Department of Primary Industries

Springvale Colliery Extension Project Modification 1 (SSD 5594 MOD 1) Comment on the Response to Submissions

Springvale Colliery Extension Project Modification 1 (SSD 5594 MOD 1) Comment on the Response to Submissions Detailed comments – DPI Water

Figure 1. Extracted Figure 2.1 from Jacobs' report

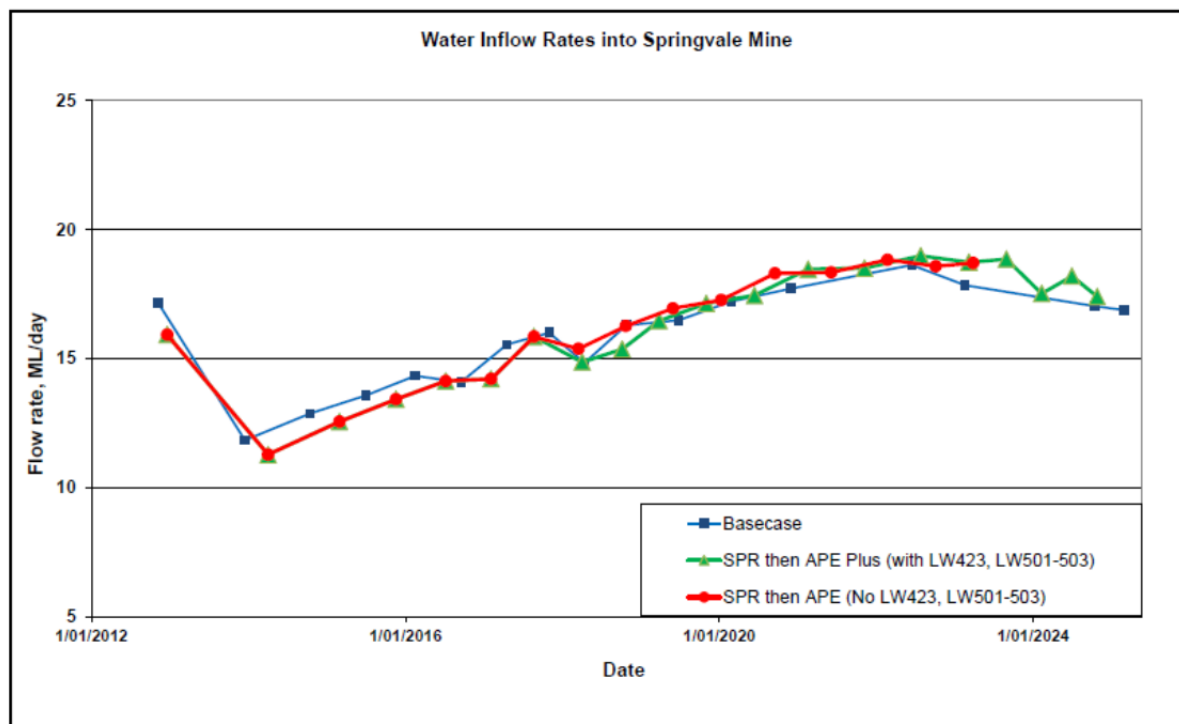
The Proponent has re-run their COSFLOW NGM for the correct mine layout and generated the necessary outputs. The outputted results now properly reflect the approved mine layout, irrespective of any business reason to exclude them (see Appendix C for an enhanced discussion). The previous work was erroneous and poorly explained. The revised outputs are shown in Figure 1 and are very similar to the original. Following this, the Proponent's analysis of the results depicted in Figure 1 is presented.

DPI Water accepts this analysis.
